5 June 2026

Planning Application No 3/2026/0078
Land at Causeway Farm, Longsight Road, Balderstone, BB2 7HZ
Outline application for up to 85 no. residential units with access applied for off A59 Longsight Road

Land Use & Access Parameters Plan
 This drawing forms part of the application for outline planning permission.

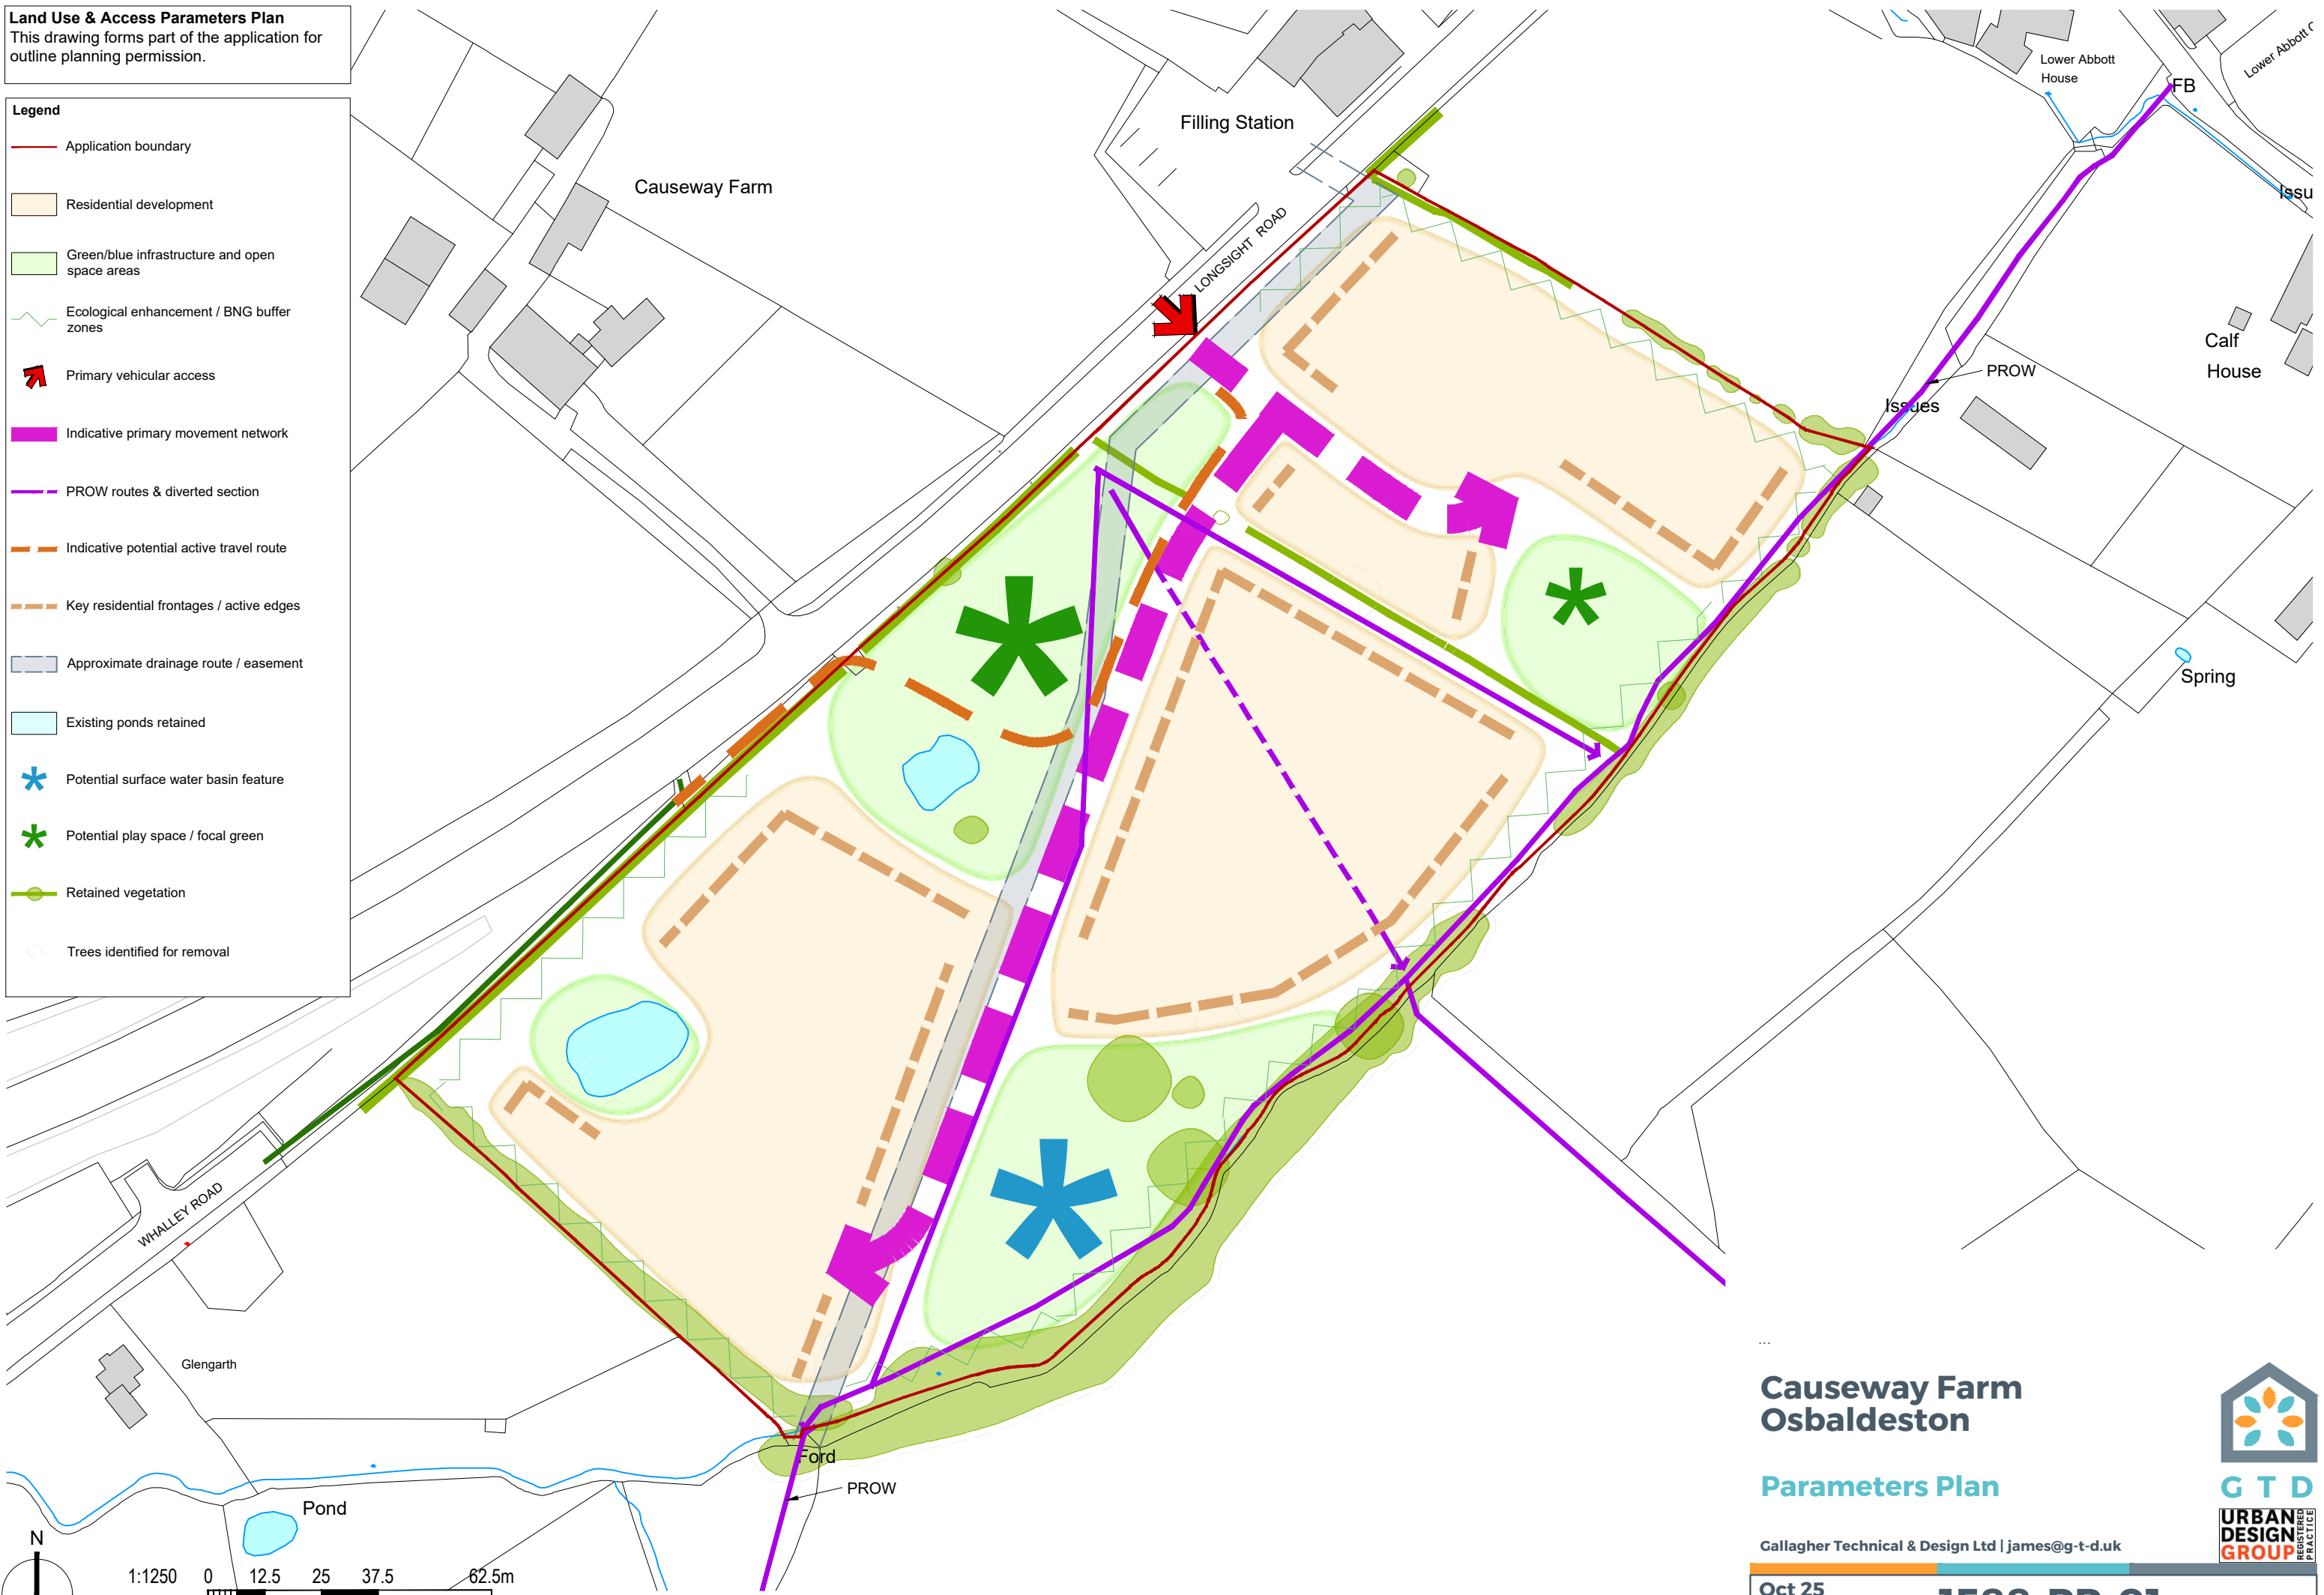
10. Due to the road safety issues mentioned earlier, there would need to be good visibility splays provided at the access onto the A59. The 2.4m splay shown on the application drawings is likely to be deemed inadequate, and a wider splay together with the length of splays required will lead to the need to remove a long length of hedgerow along the A59, with further loss of habitat.
